Our Ref: PEF/SD/28854
Your Ref: Y/21/18/DOC

10 May 2018

**Drainage
Land at Kings Close, Yapton**

King Post Retaining Wall Details (Wall on West Boundary)

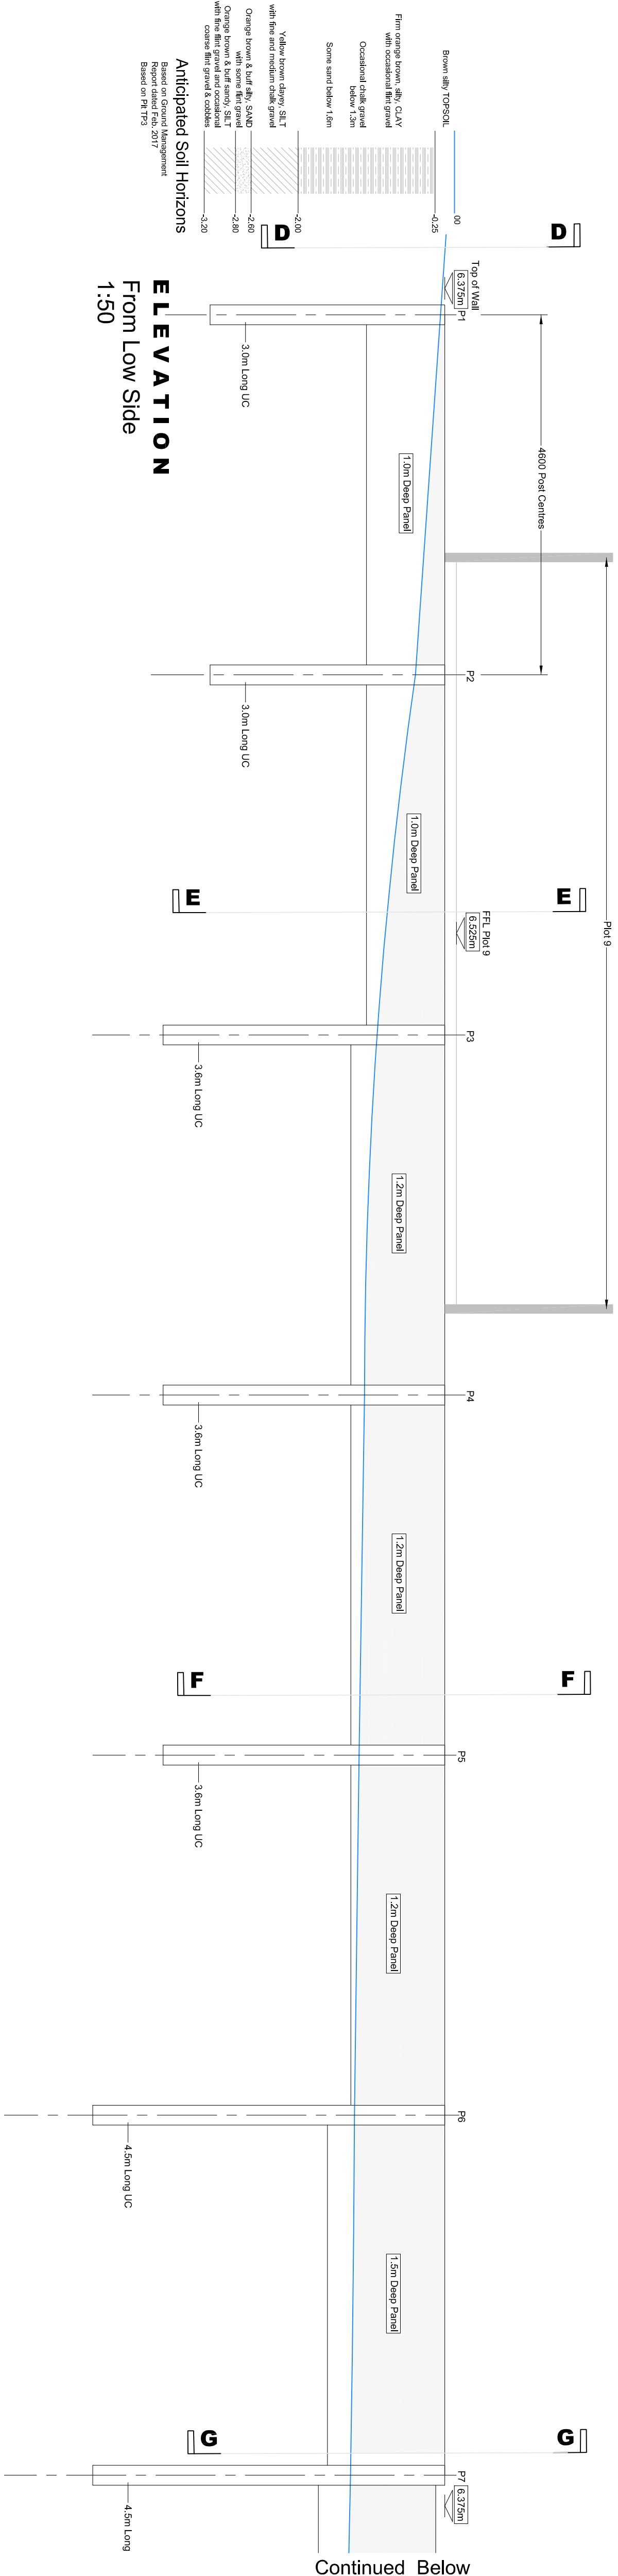
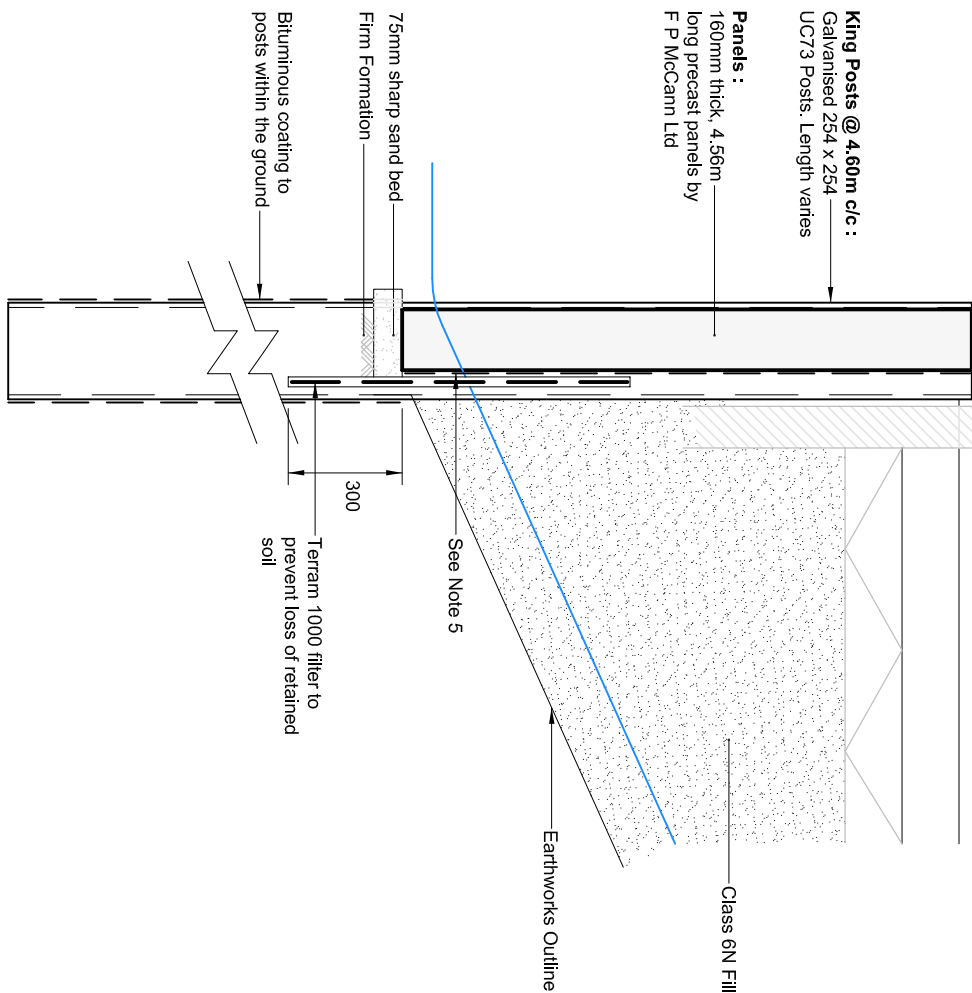
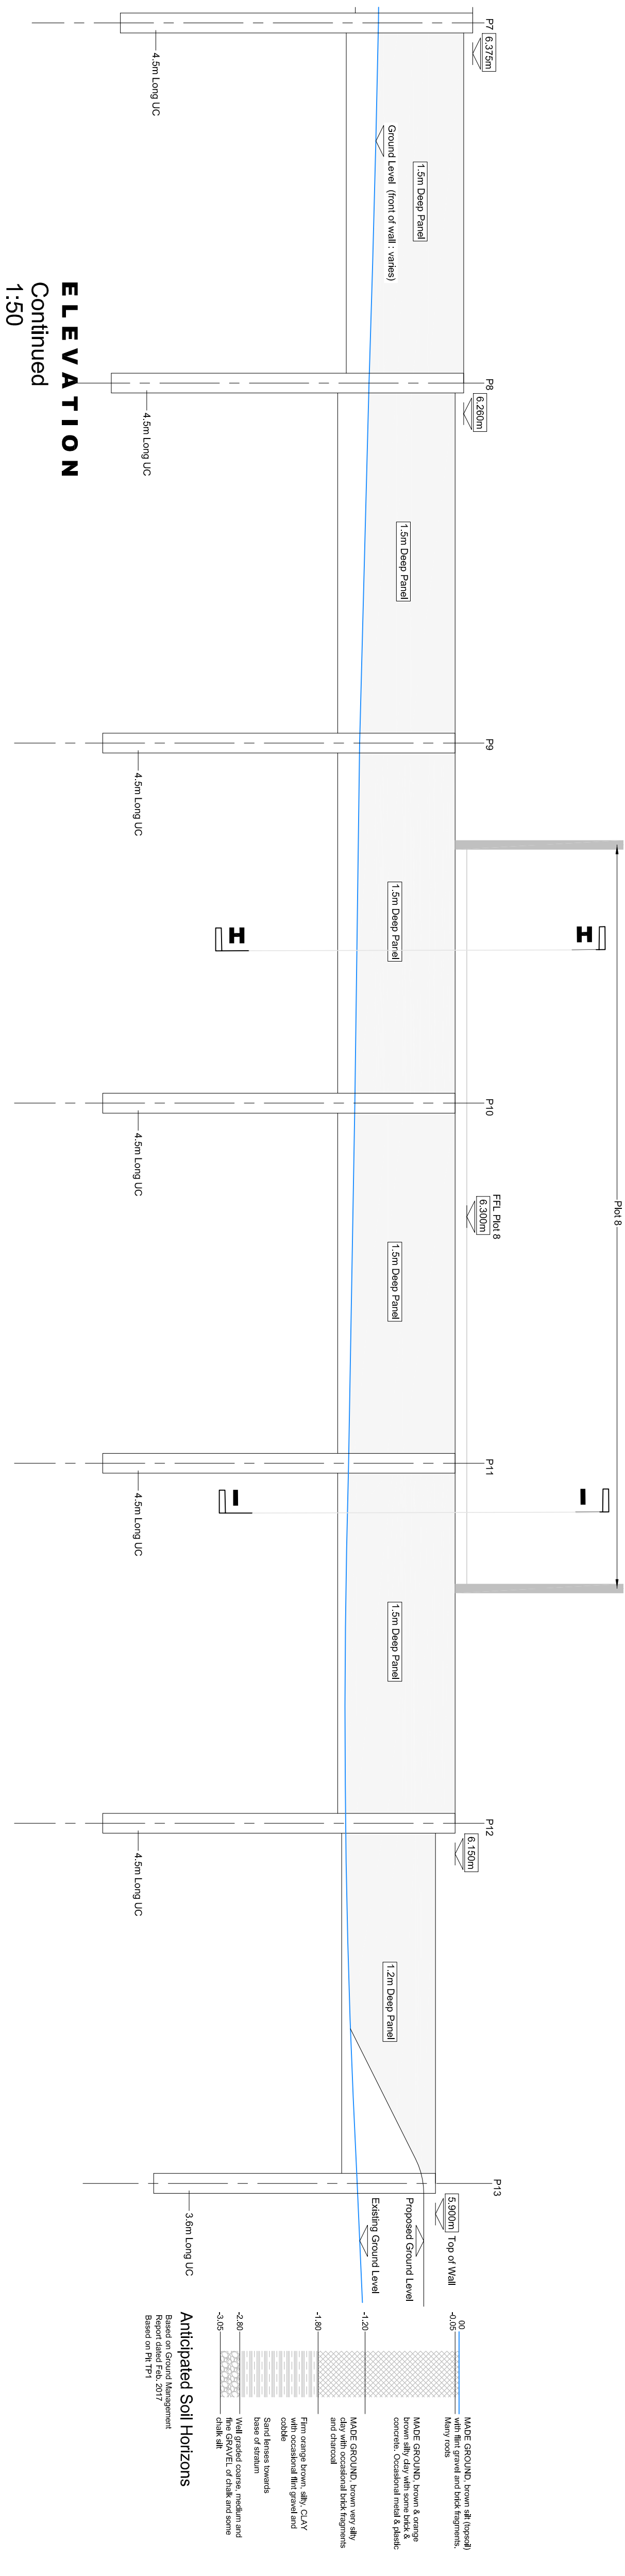
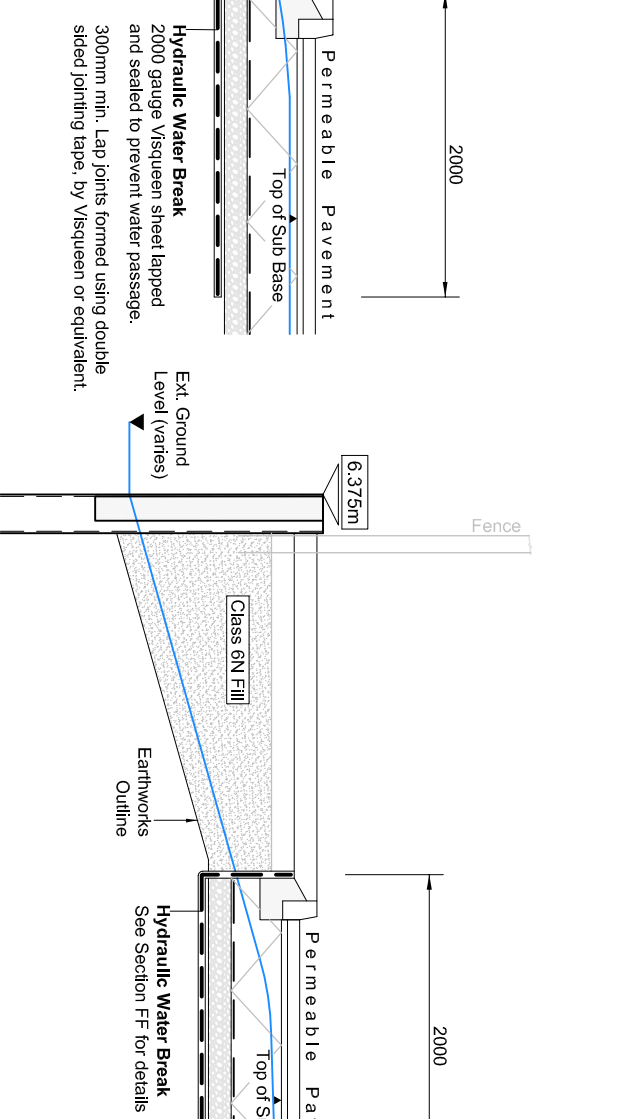
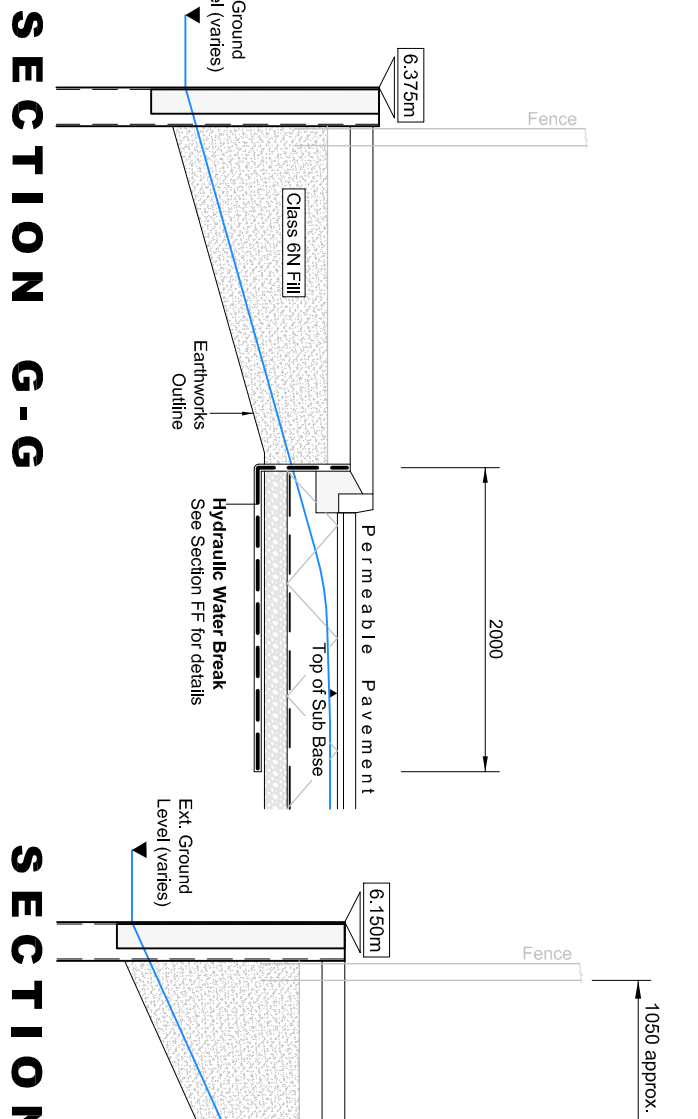
- 1) The high storage soakaways have been redesigned such that the half drain time does not exceed 24 hours. See Micro-Drainage calculations.
- 2) In order to control exceedance flow in the vicinity of Kingshaven, I have introduced a raised speed table and permeable paving. See drawings 28854-101.P5 and 102.P3.
- 3) Free draining Class 6N backfill is being provided behind the new retaining walls. See drawing 107.P2. I have also introduced a hydraulic break at the edge of the permeable pavement on the west boundary of the site. The hydraulic break will help retain storm water within the base of the permeable pavement and restrict flow towards and through the new King post retaining wall.
